From: Carla Thompson [<mailto:Carla.Thompson@Brown-co.com>]
Sent: 15 June 2015 11:28
To: A14 Cambridge to Huntingdon
Cc: [REDACTED]
Subject: TR 010018 - 10030962. J. W. Burgess & Sons Ltd Deadline 2 Representations

TR 010018/10030962
J. W. Burgess & Sons Ltd.
No reference and not on website

Deadline 2 Representations

**CONINGTON ROAD REALIGNMENT  
WORK NO. 17 - WORKS PLANS SHEET NO. 15**

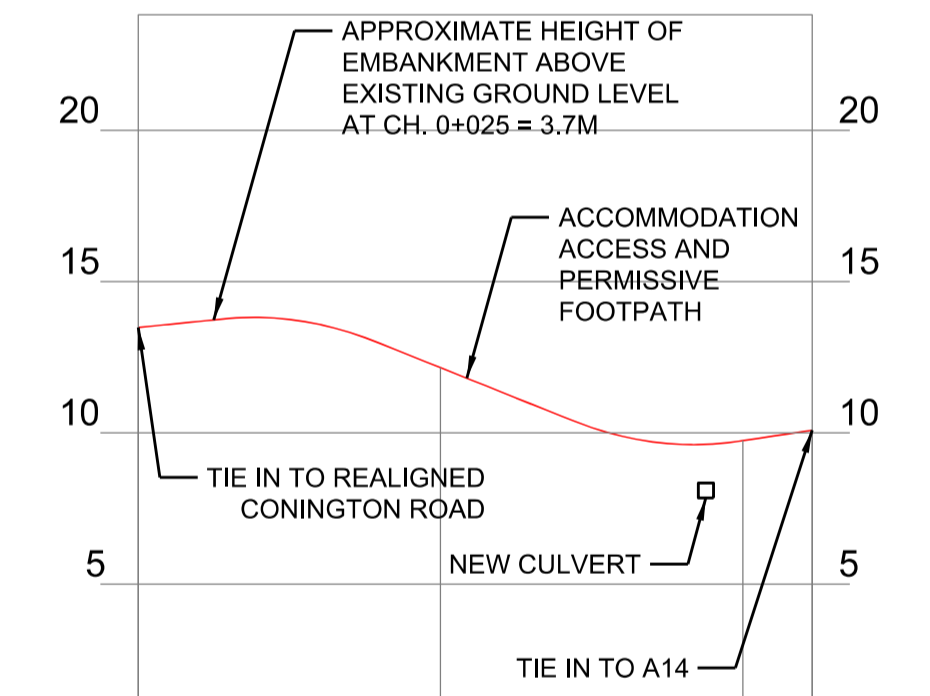
4. Our client notes the configuration of new means of access numbered 2, in particular the need to embank the same. It will be important that an adequate and safe access be provided with turning circles sufficient for agricultural traffic.

- (ii) The new means of access is shown as embanked which may potentially restrict the existing access which is at grade. Our clients seek to ensure that the new embanked access will be constructed to a standard and width to be equivalent to existing highway access and to a standard which caters for agricultural traffic in particular articulated lorries and tractors and trailers. The new access arrangements must be to at least an equivalent status to those that exist already.
